**MAJOR PROJECT ASSESSMENT
CONCEPT PLAN APPLICATION FOR A
COMMERCIAL AND RETAIL DEVELOPMENT
86-96 and 100 Mount Street, North Sydney**

MP 08_0241

Director-General's Environmental Assessment Report
Section 75I of the
Environmental Planning and Assessment Act 1979

April 2010

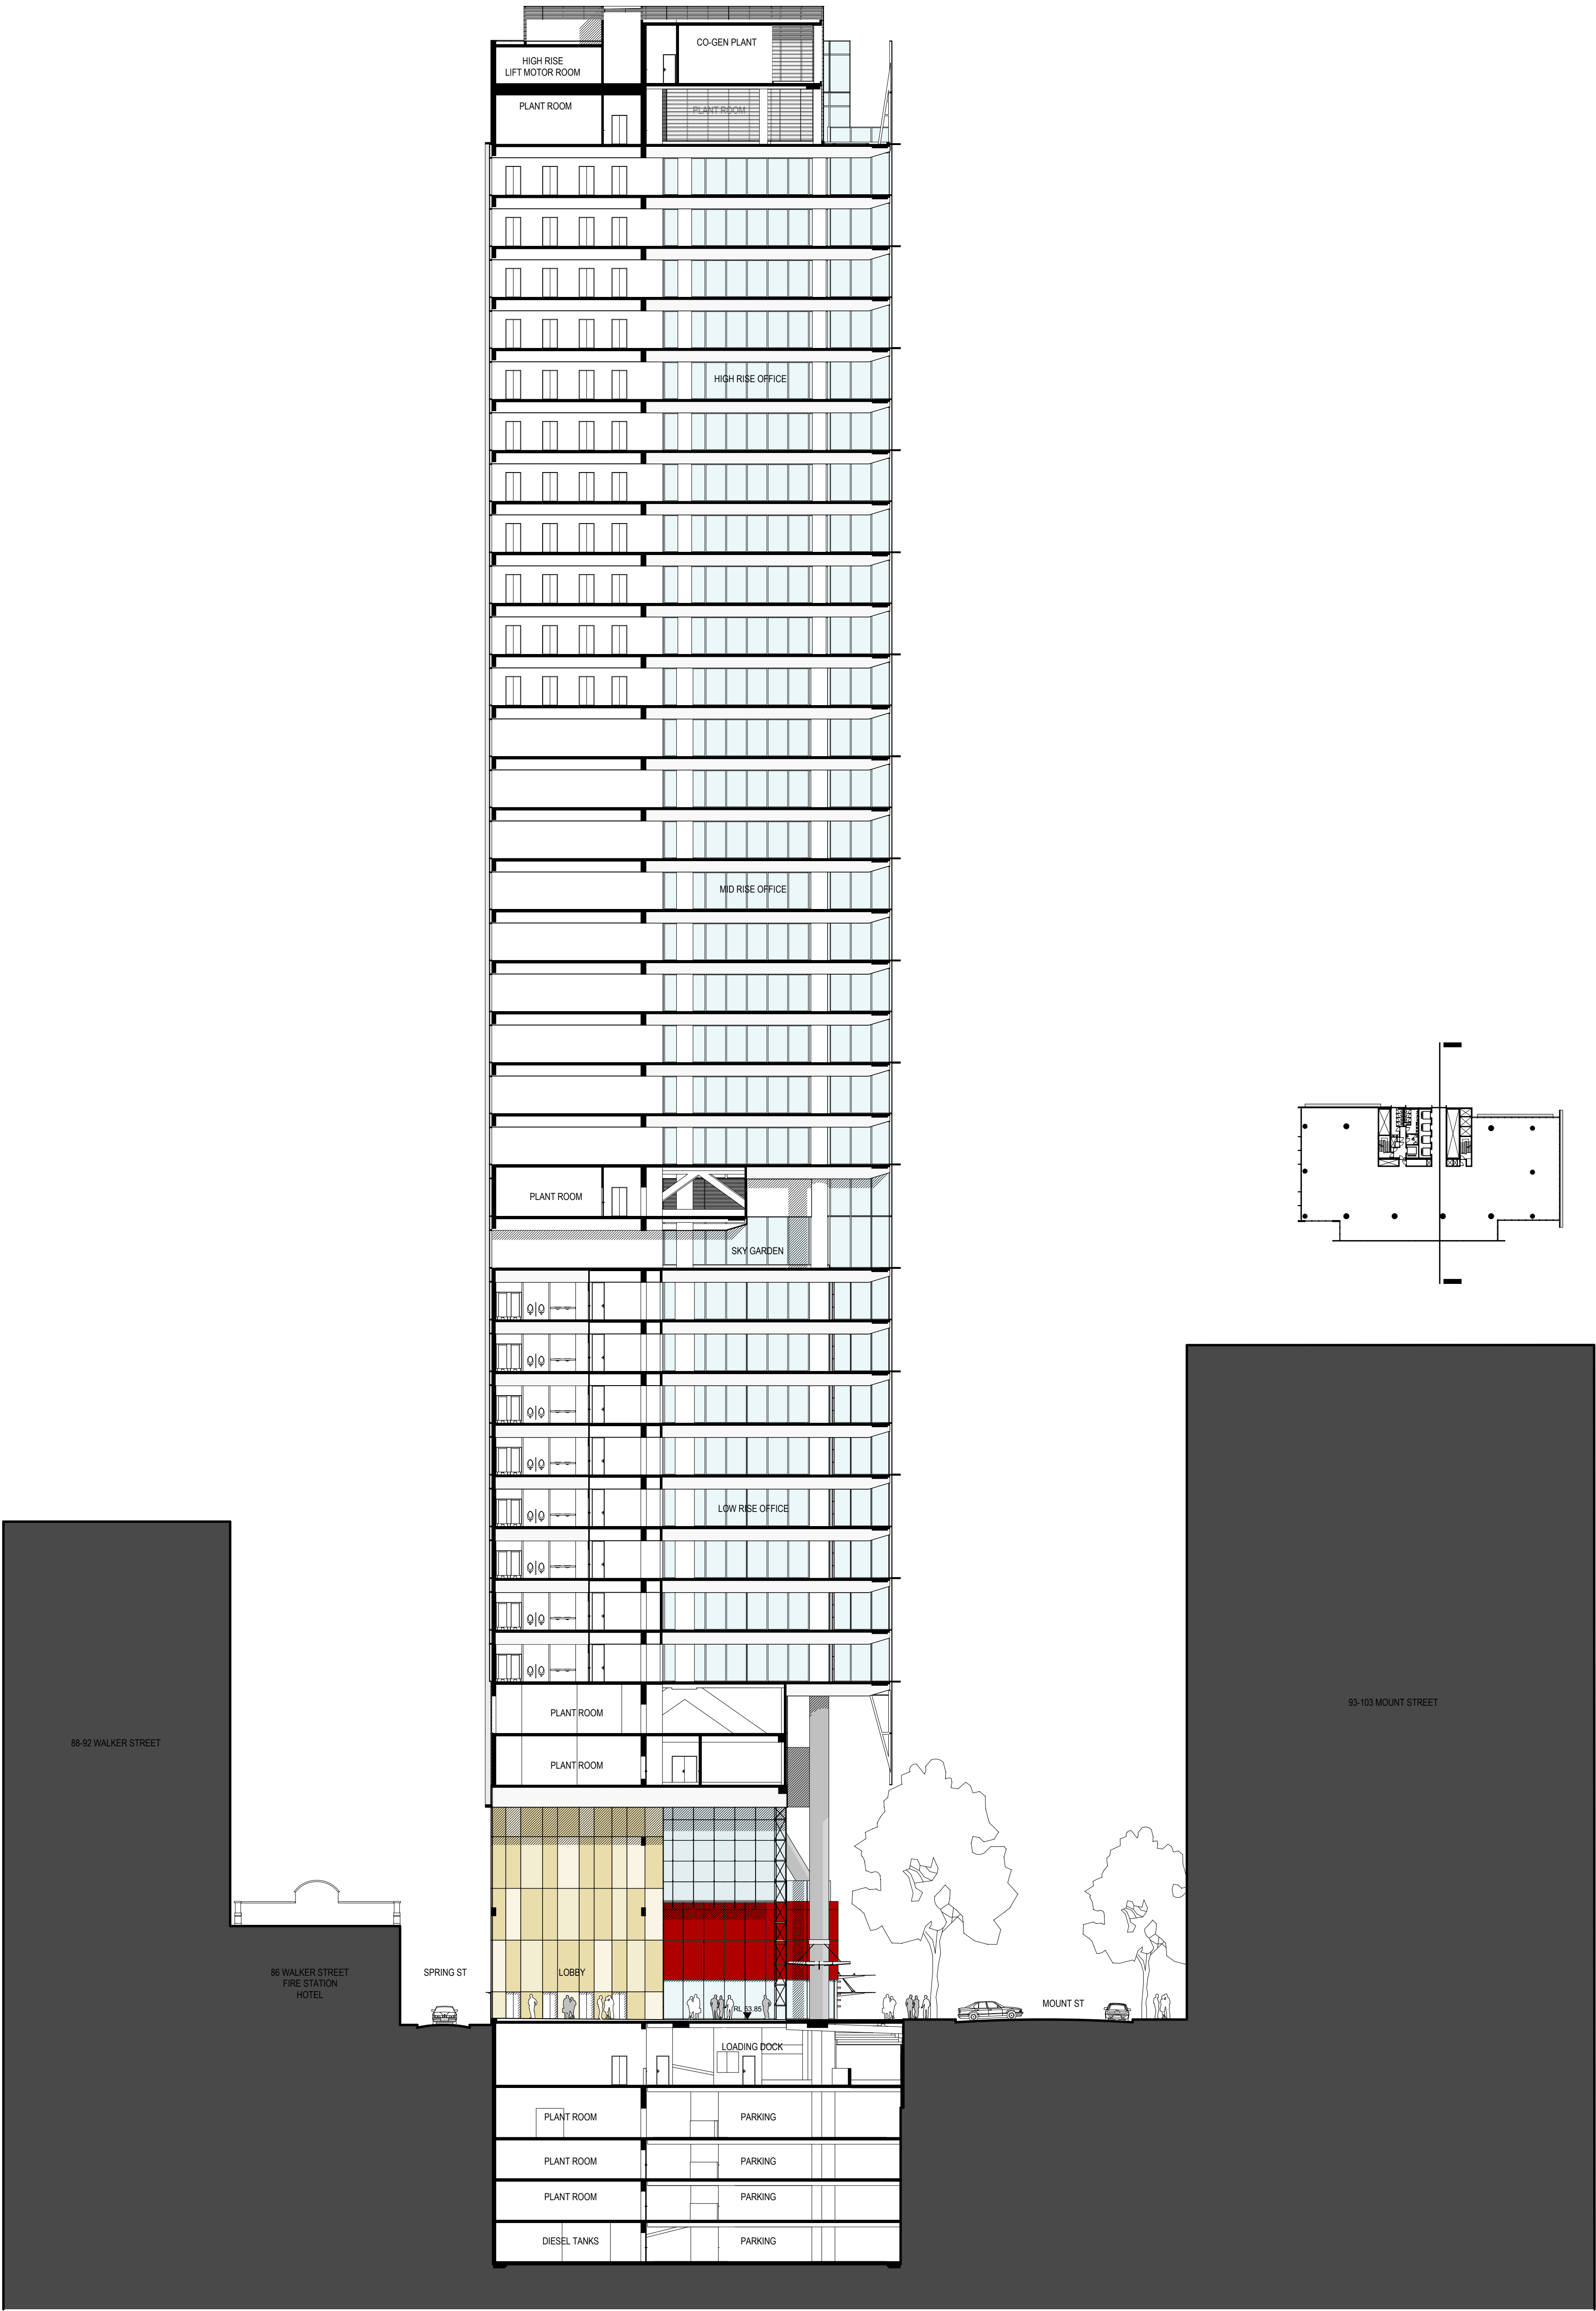
- The building height exceeds the current LEP 2001 and North Sydney Draft Local Environmental Plan 2009 ("Draft LEP") height controls resulting in additional shadowing of public and private land, however, this shadowing is considered acceptable in the context of the site and locality, and the intent of the Draft LEP controls. The height non-compliance with the Draft LEP is 4.7 metres and relates only to the plant room levels of the PPR proposal.

- The main variation to setback compliance occurs on the Walker Street frontage where a minimum weighted average setback of 5 metres is required and only 3.58 metres is proposed. A modification is recommended to increase the setback of the upper tower by a further 2.0 metres resulting in greater compliance with the weighted average requirement.

- Increase in setbacks to Walker Street at levels 17 to 36 to provide closer compliance with North Sydney City Centre DCP controls and ensure an appropriate response to the Walker Street streetscape;
- Construction management conditions, including restrictions on construction hours;
- Reduction in parking from 123 spaces to 97 spaces to comply with Council's DCP 2002; and,
- Additional monetary contribution of \$10,000 towards upgrading the intersection of Walker and Mount Streets.
